City of Albuquerque Planning Department
One Stop Shop – Development and Building Services

Application Number: 09AA-10168, Amndt Site Development Plan - Bld Prmt

Location Description: TRAMWAY BLVD NE BETWEEN INDIAN SCHOOL NE AND ROVER NE

Project Number: 1003082

ADMINISTRATIVE AMENDMENT
 File # 09AA10168 Project # 1003062
 New lot lines to create three lots. Revised parking. Cross parking agreement necessary.
 Approved by [Signature] DATE 03 Nov 09

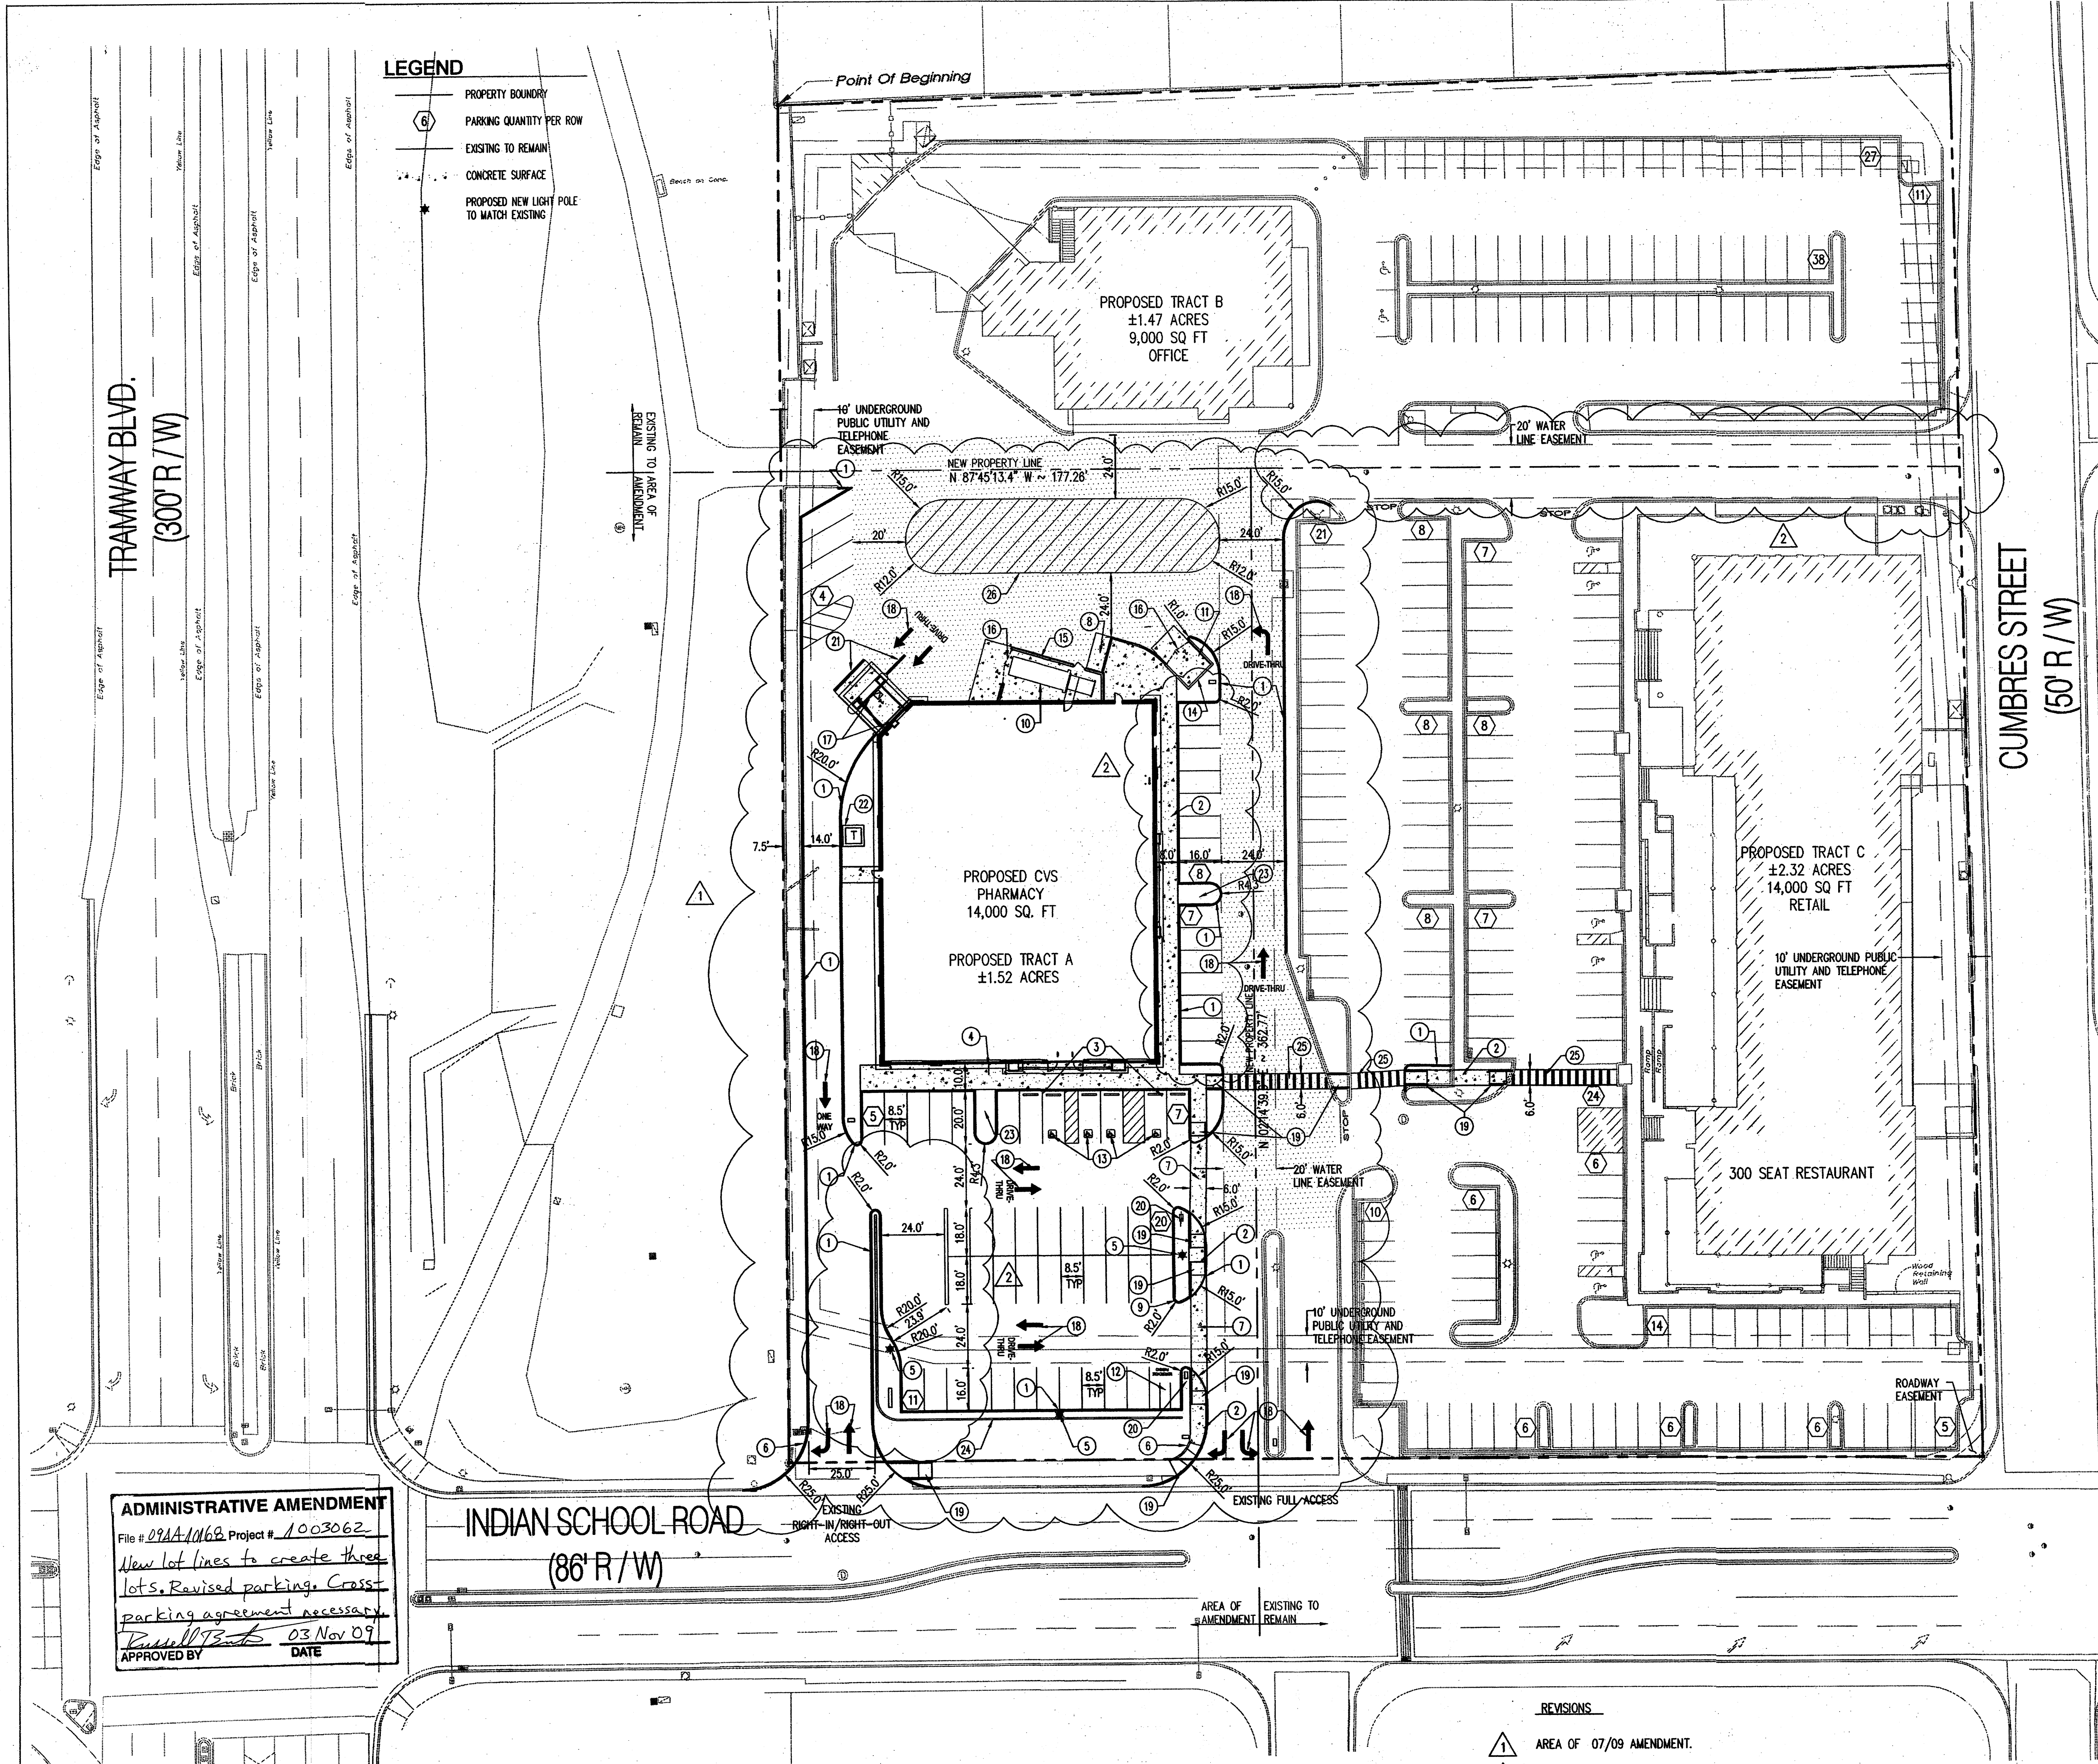
PLANNING (505) 924-3858			
PLANS DISAPPROVED	DATE	DATE	DATE
PLANS APPROVED <i>PSS</i>	DATE <i>04 Nov '09</i>	DATE	DATE
COMMENTS:			
<i>Rec'd 10-20-09</i>			
<i>New lot lines to create three lots. Revised parking. Cross-parking agreement necessary.</i>

TRAFFIC CIRCULATION LAYOUT

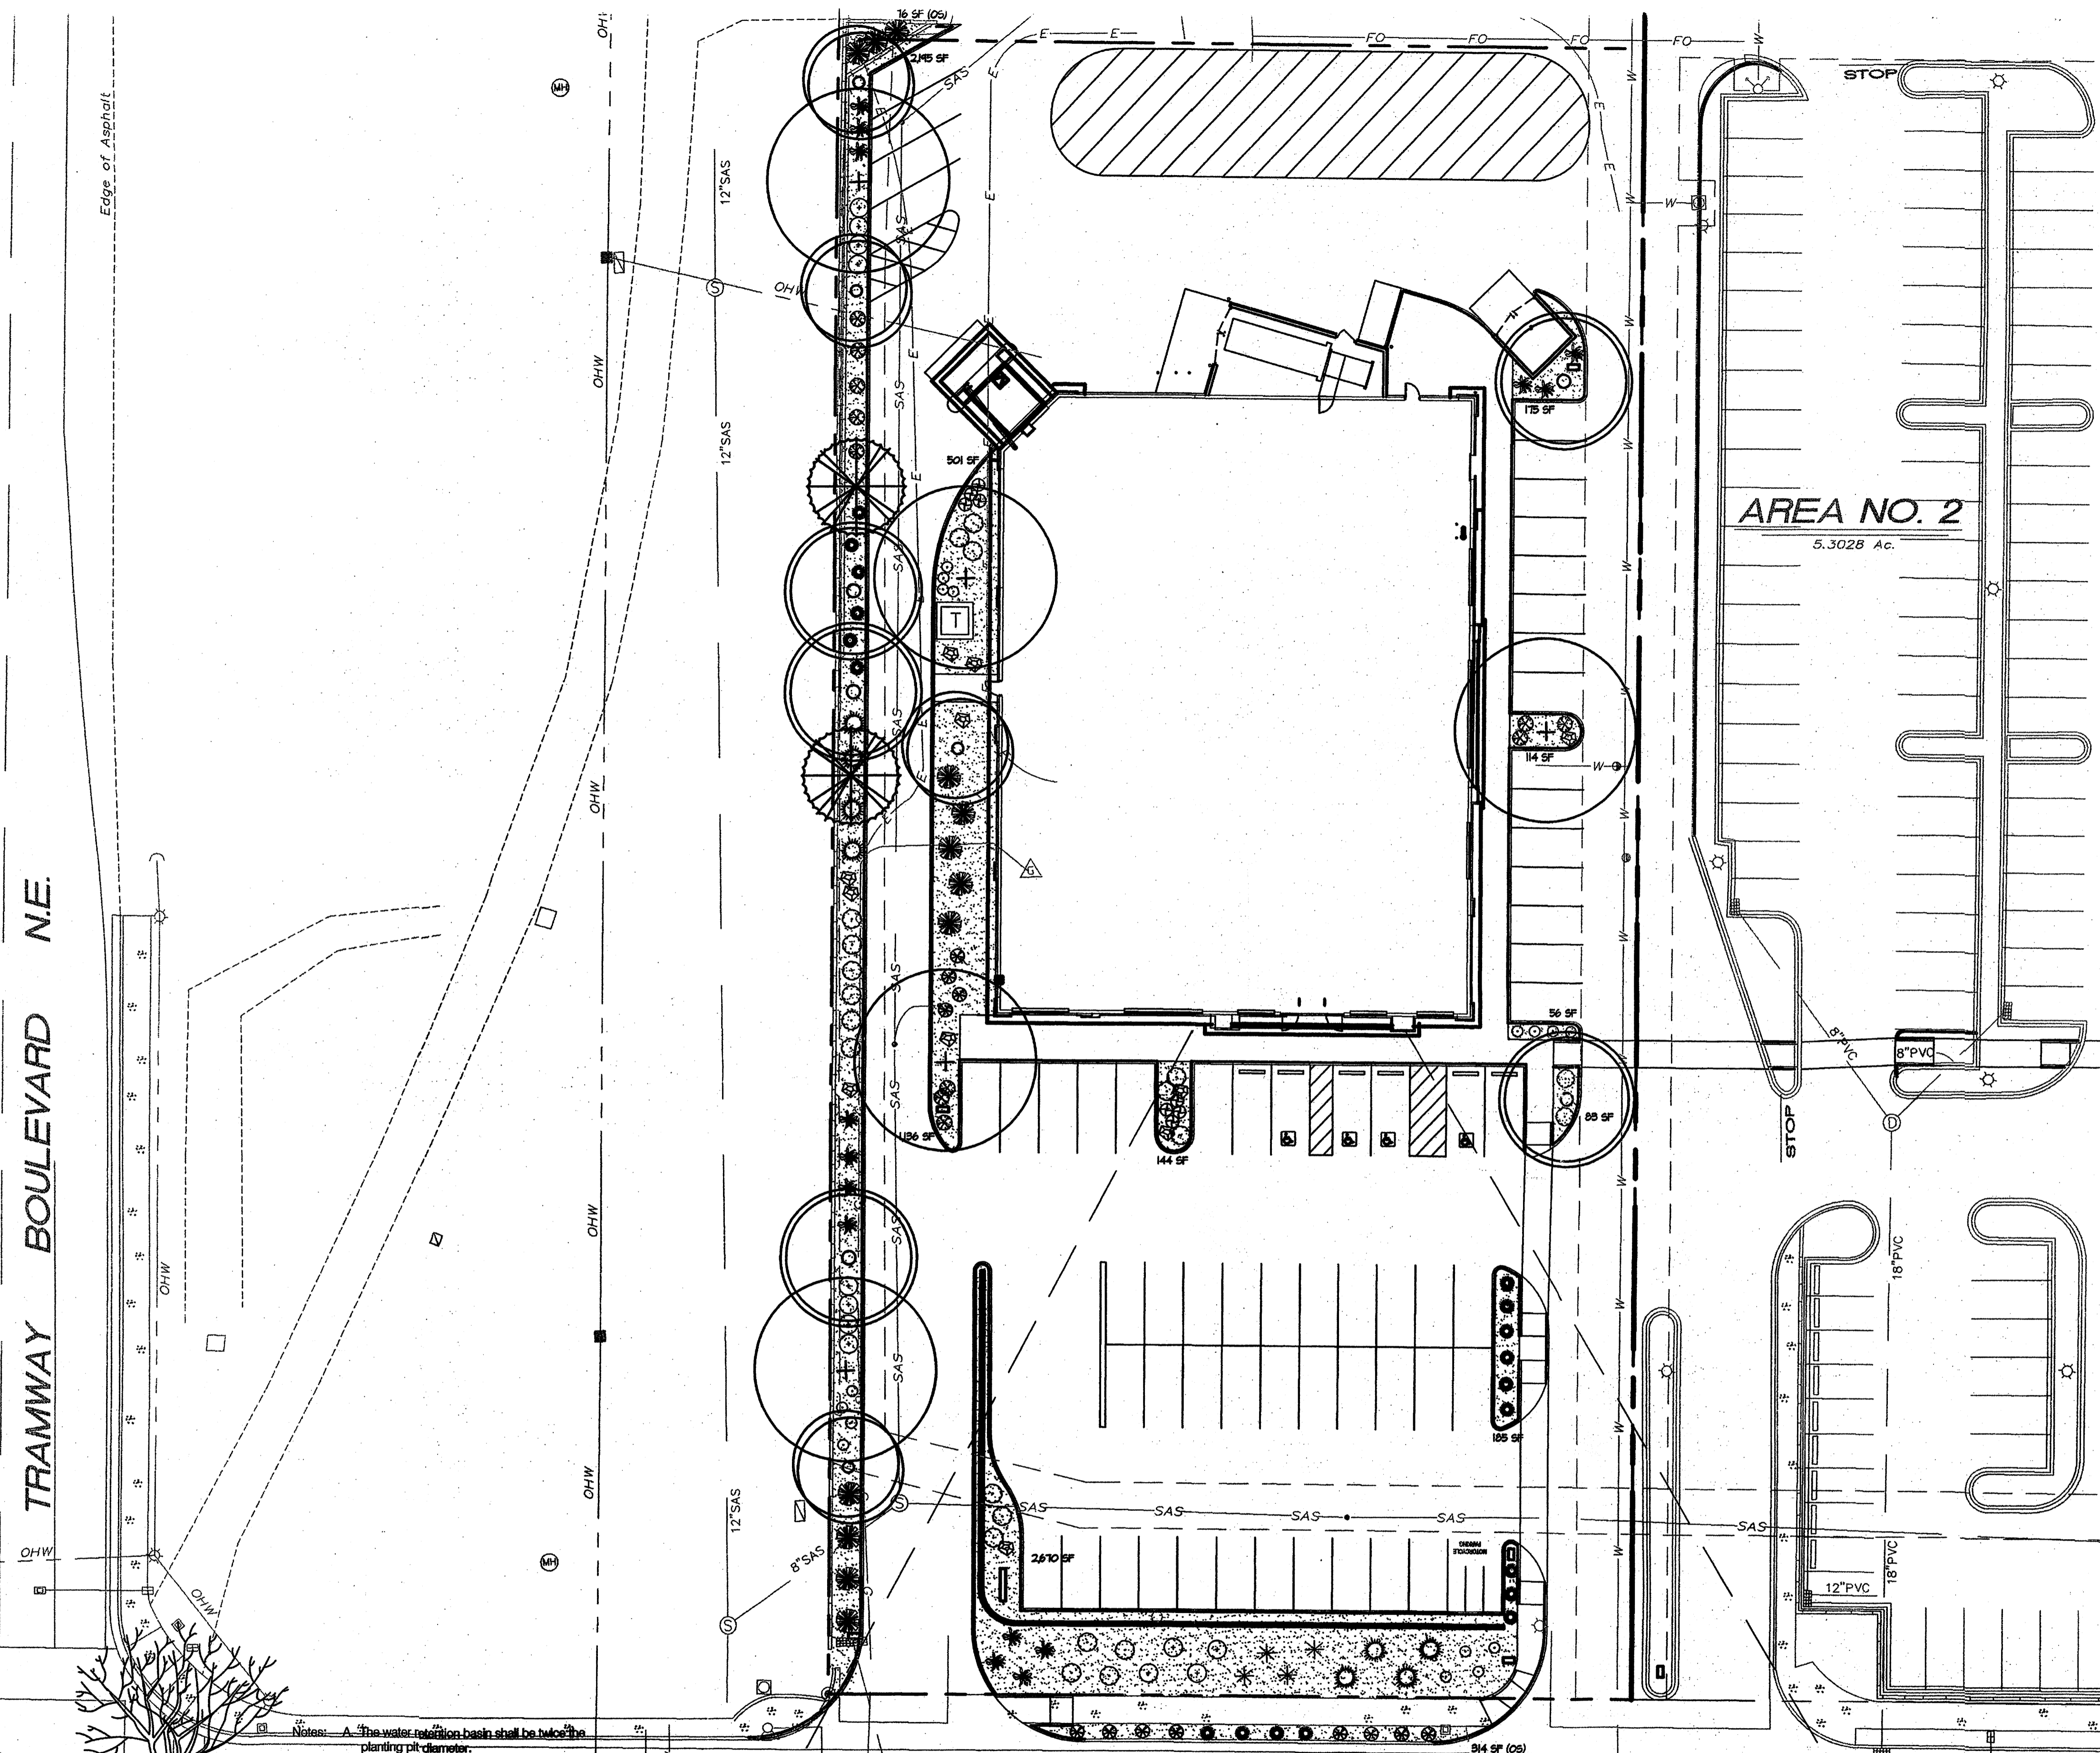
TRANSPORTATION DEV (505) 924-3990			
PLANS DISAPPROVED <i>NSE</i>	DATE <i>10/29/09</i>	DATE	DATE
PLANS APPROVED <i>NSE</i>	DATE <i>10/29/09</i>	DATE	DATE
COMMENTS:			
<i>Discuss overall site vs approved ΔΔ, see Site Plan marked Transp.</i>
